9 October 2019

MIXED USE DEVELOPMENT (SSD 9827) 45 HONEYSUCKLE DRIVE NEWCASTLE

The Environmental Impact statement (EIS) of the application has been reviewed by CN officers and the following advice is provided for your consideration:

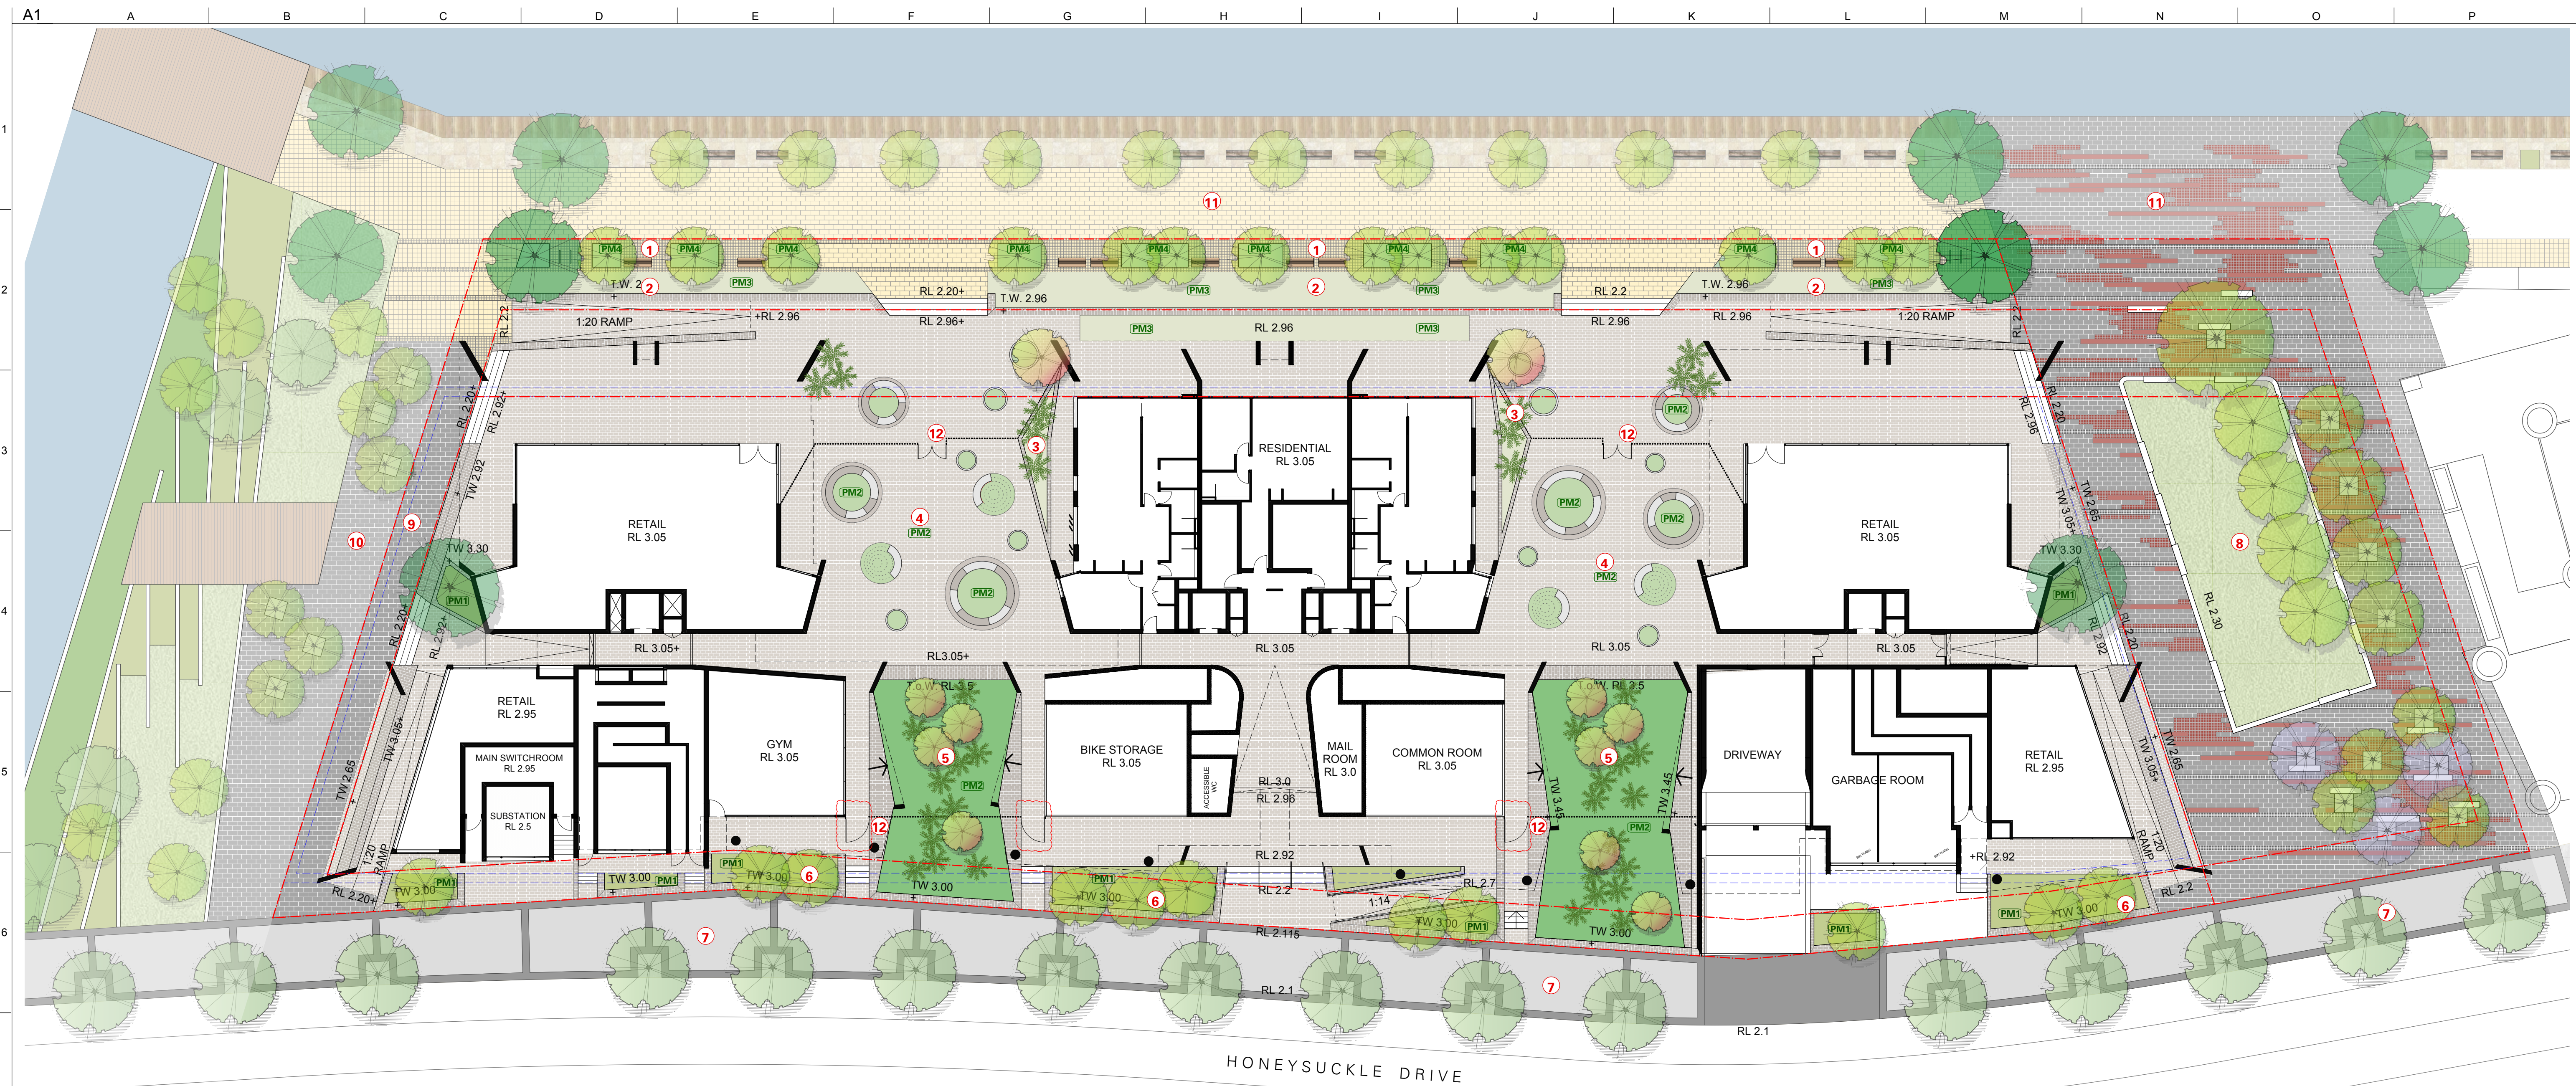
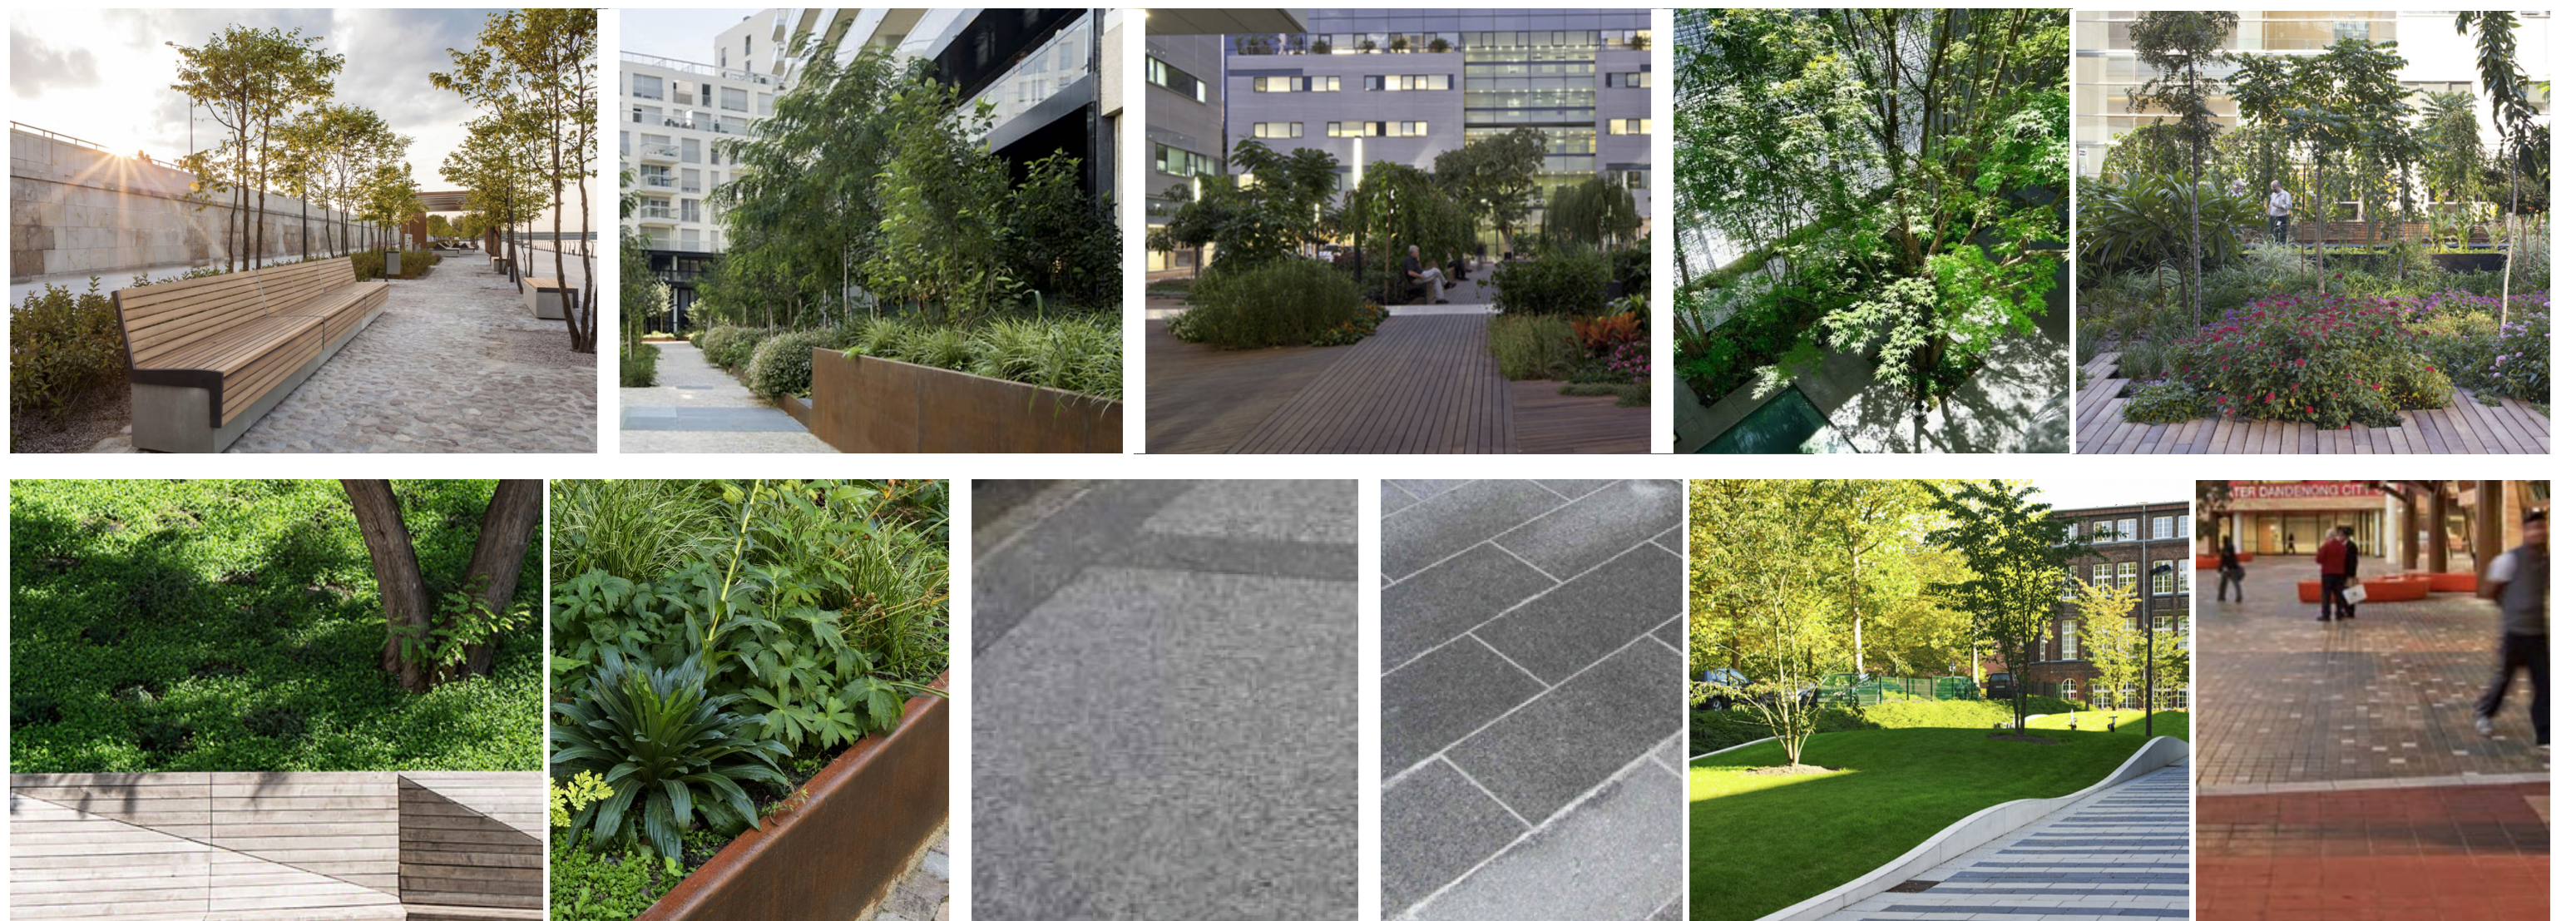
The EIS indicates that the development will provide pedestrian links through to the harbor from Honeysuckle Drive. The Site Analysis Plan (DA-007 C) indicates three 'Pedestrian Through Links', two between the three buildings and another along the Steel Street Floodway. However, the Landscape Concept Plan show fences and gates constructed across the harbour side of the pedestrian links between the buildings. Further, these areas

are identified as 'internal courtyards'. It is recommended clarification is sought from the applicant as to the purpose of the above areas and the location of the pedestrian links.

The Steel Street Floodway works needs to be built at a level of 2.3m Australian Height Datum (AHD) in accordance with the Honeysuckle Redevelopment Area Flood Study (March 2018) prepared by BMT for the Hunter and Central Coast Development Corporation (HCCDC). The submitted landscape and architectural plans do not satisfy this requirement and need to be modified. Any landscaping in the floodway must not impede the design floodwaters and cause upstream flood impacts. The raised garden bed in the Steel Street Floodway cannot be above ground as required by the above Study, unless it can be demonstrated by a flood impact assessment that it is satisfactory and will have negligible impacts.
